Comments from Environmental Health and Private Sector Housing:

APPLICATION BR/161/17/PD

Registered: 8th June 2017
Site Address: 6 York Road Chambers York Road Bognor Regis PO21 1LT

Description of Works: Notification for prior approval under Part O for change of use from office (ClassB1(a)) to 14 No. residential apartments (Class C3)

DRAWING TITLE
CONVERSION OF OFFICES TO
RESIDENTIAL
PROPOSED FIRST FLOOR PLAN

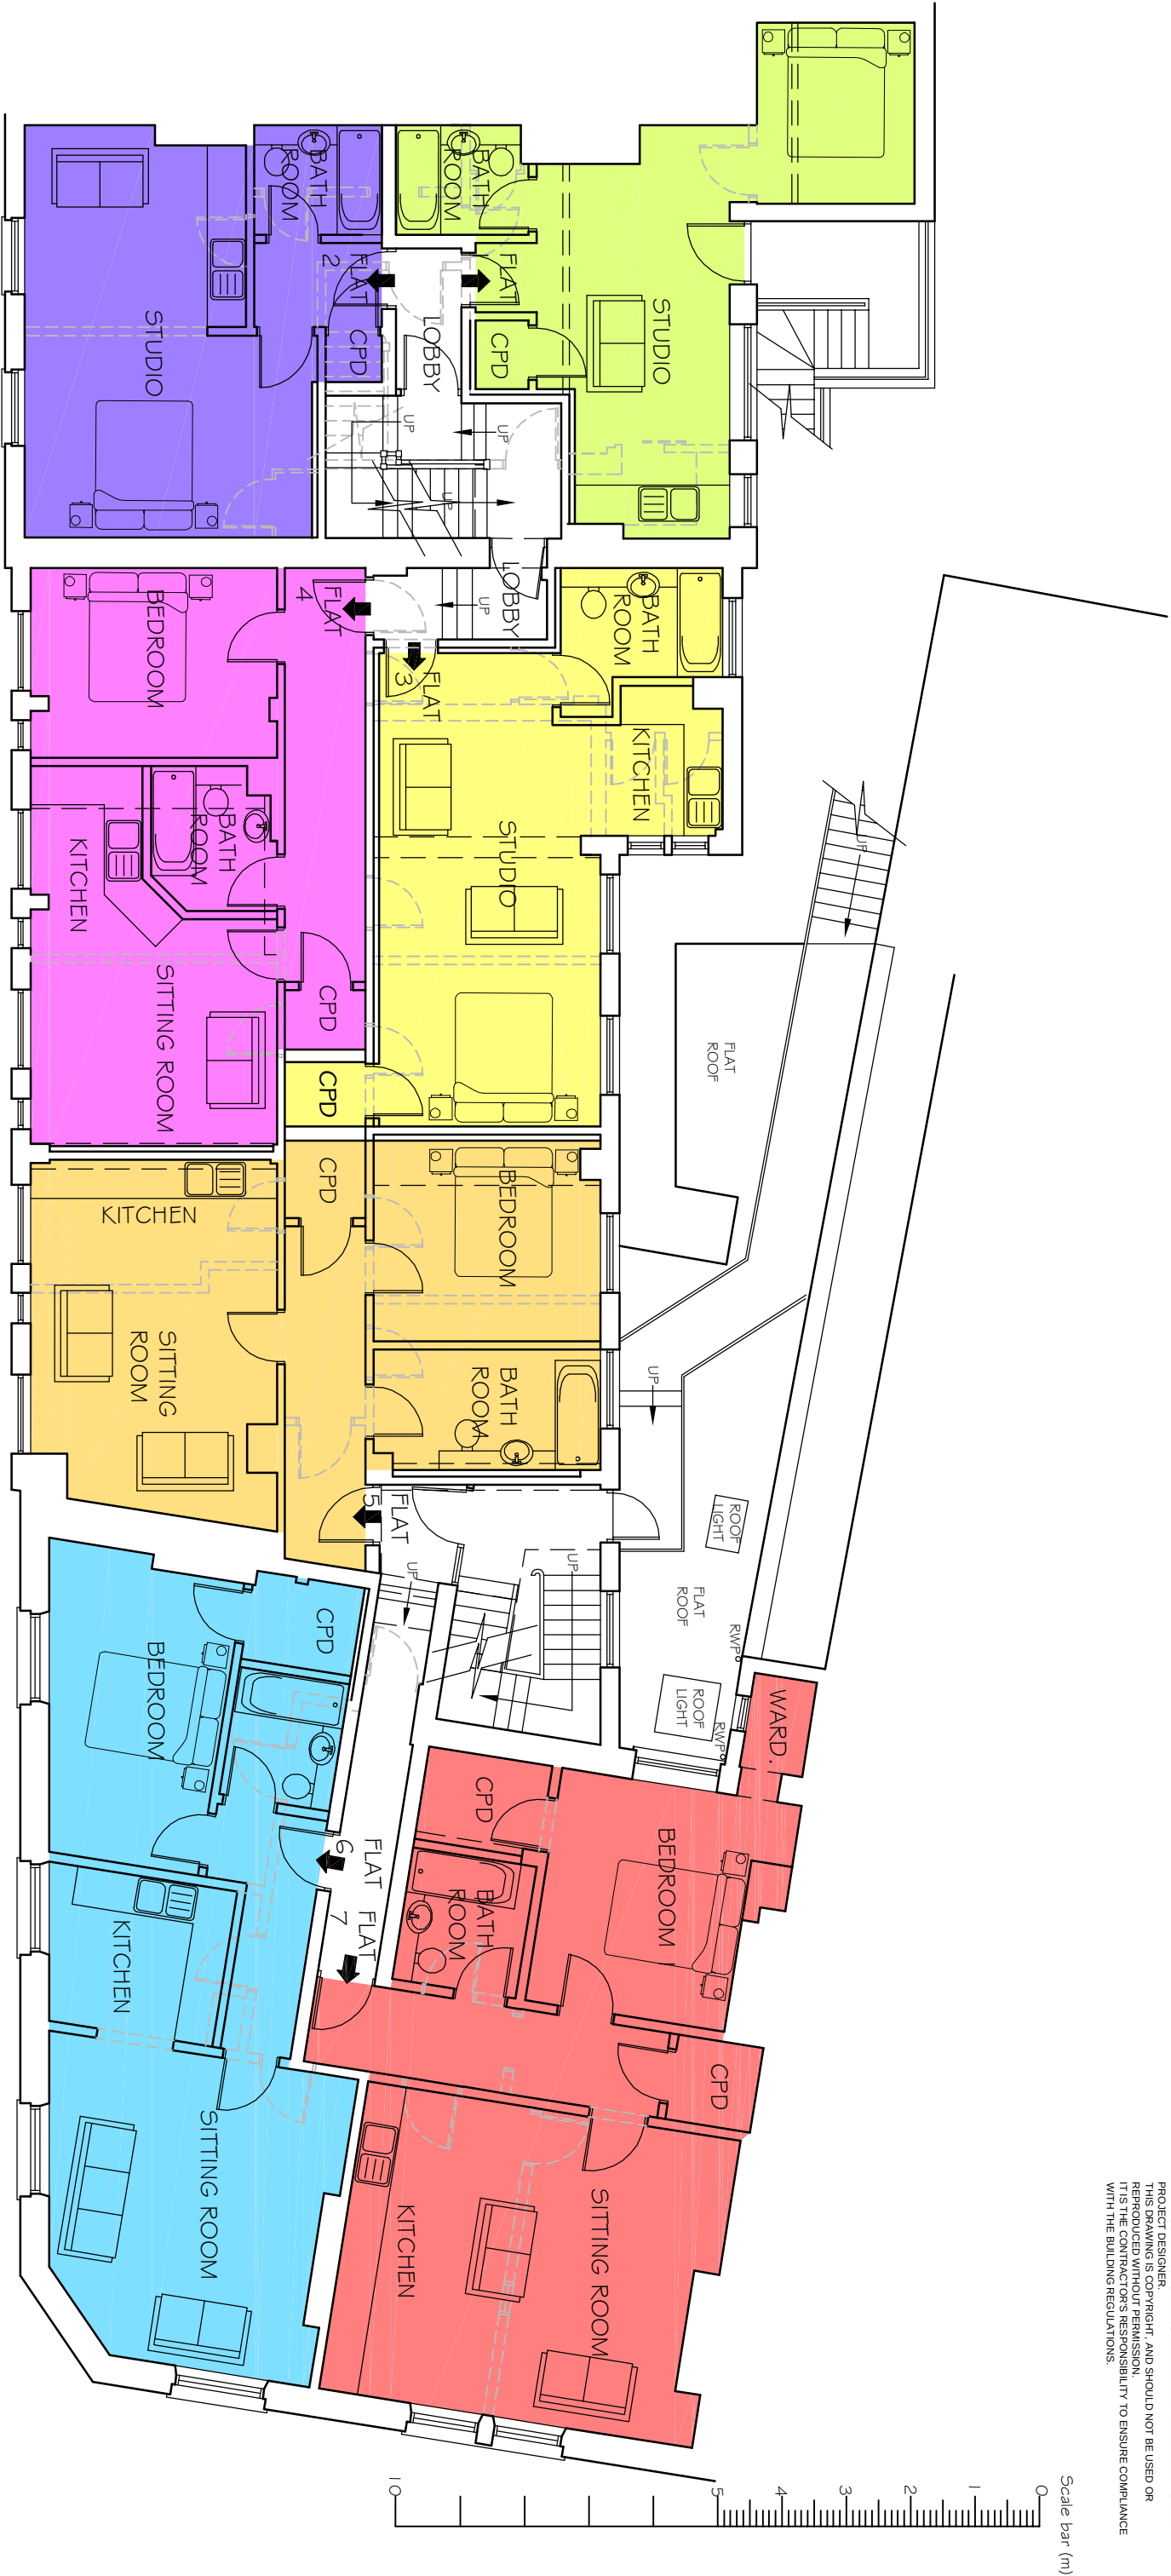
- The external staircase which is serving as a means of escape from the flats should be protected from the effects of fire along its length. The sensitive area is 1.8m horizontally therefore any windows in this region should be fire resisting construction and if possible fixed shut and any doors should be fire resisting and self-closing.

- A room where the only escape route is through another room is termed an “inner room” and poses a risk to its occupiers if a fire starts unnoticed in the outer room. The escape routes from the bedroom in the first floor studio flat is via the kitchen, this can be overcome by ensuring that an escape window is provided and adequate fire protection within the flat.

- Any bathrooms and kitchens without windows for natural ventilation should have adequate mechanical ventilation.
